From: Lauren Willard <[REDACTED]>
Sent: 20 February 2018 18:39
To: Amber Willard
Subject: Re: R/257/17/CLP
Attachments: 1123.01.c Existing and Proposed A1.pdf

From: Amber Willard
Date: Tuesday, 20 February 2018 16:33
To: Lauren Willard
Subject: R/257/17/CLP

I am currently looking at your application R/257/17/CLP and I think there may be an error with one of the scales. The scale for the existing and proposed elevations on drawing number 1123.01.b is 1:100 however this would make the proposed extension over 6m high .

Drawing Number: 1123.01.b

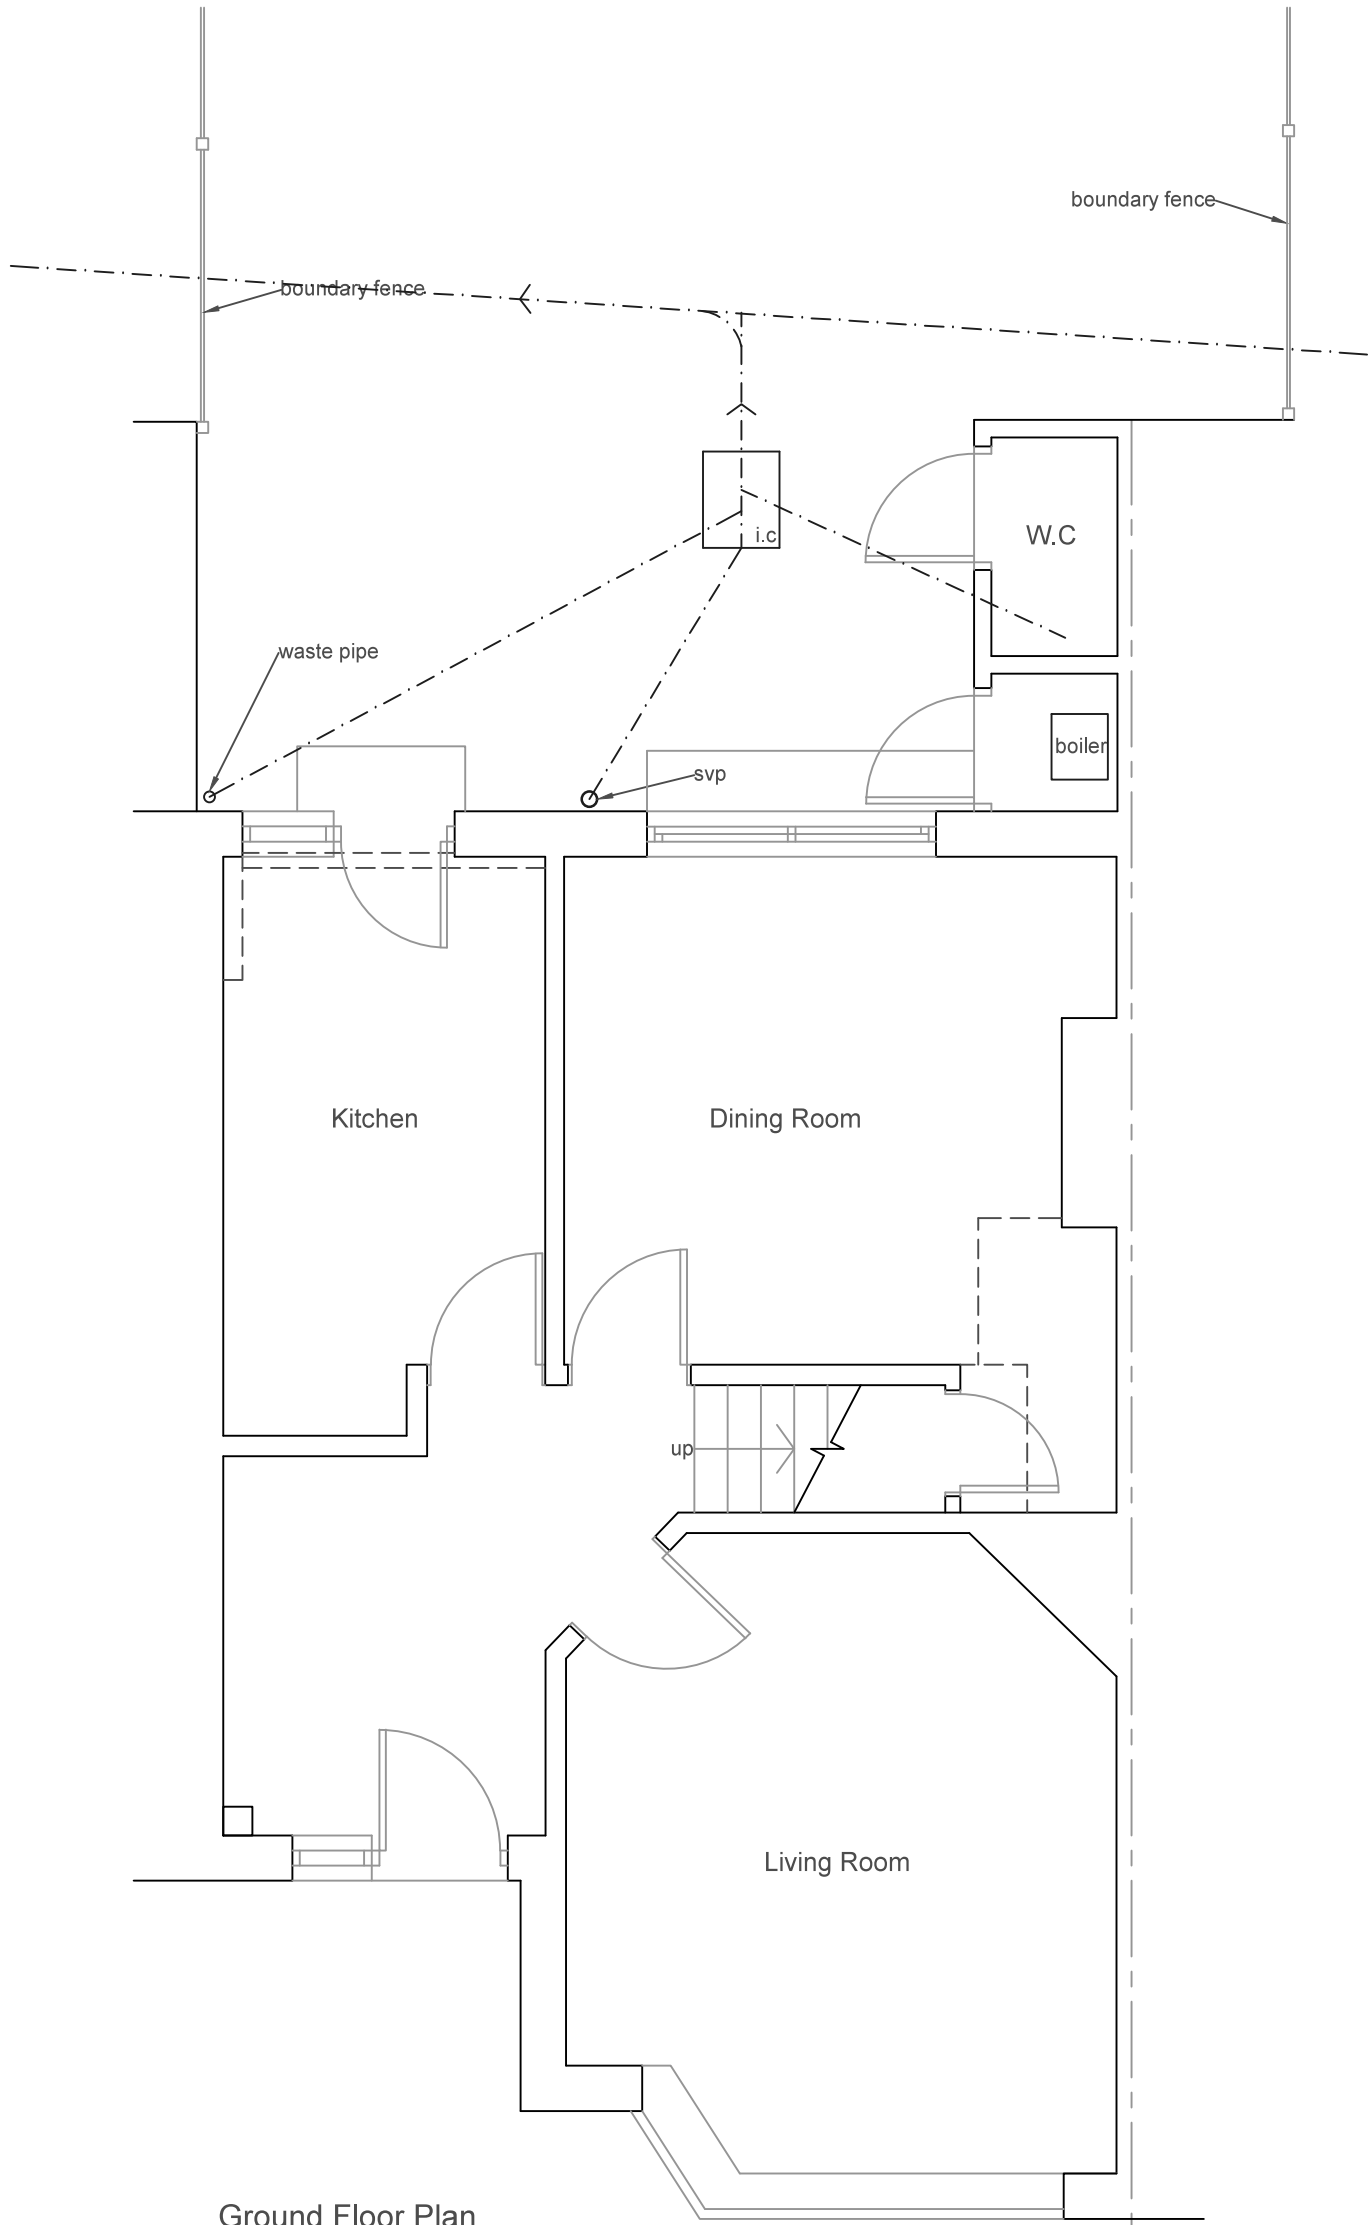
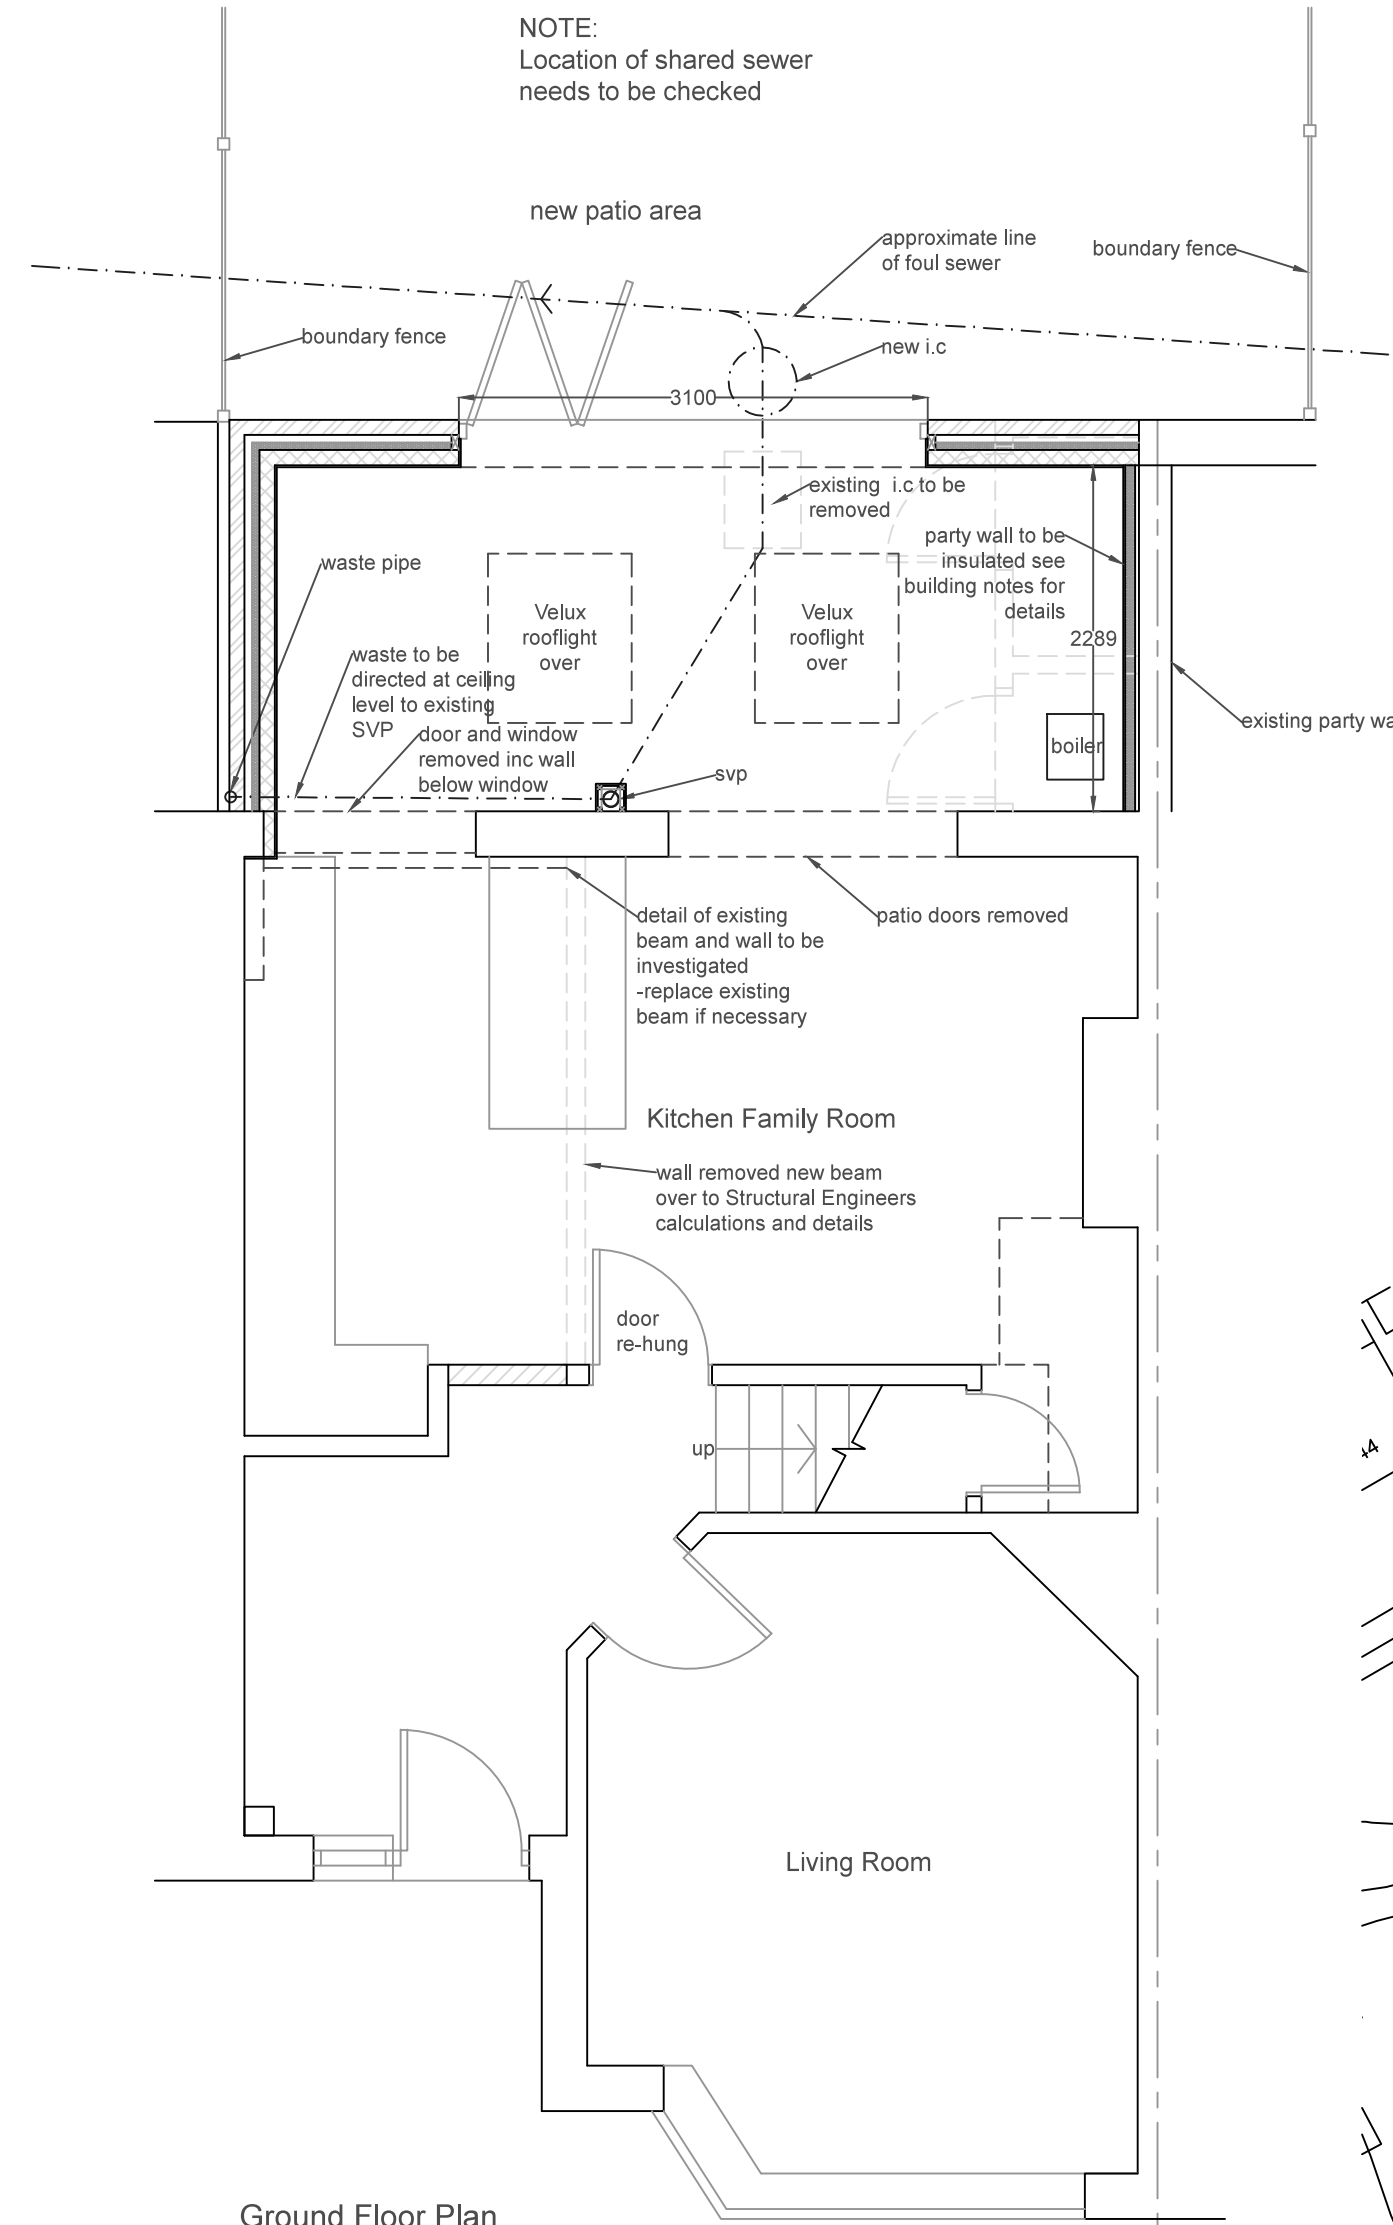
I feel as if 1:50 should be the correct scale and if this is the case please am I able to receive an amended plan showing this.

You are correct the annotation on the elevations should say the scale is 1:50 not 1:100. Please find attached the amended drawing.
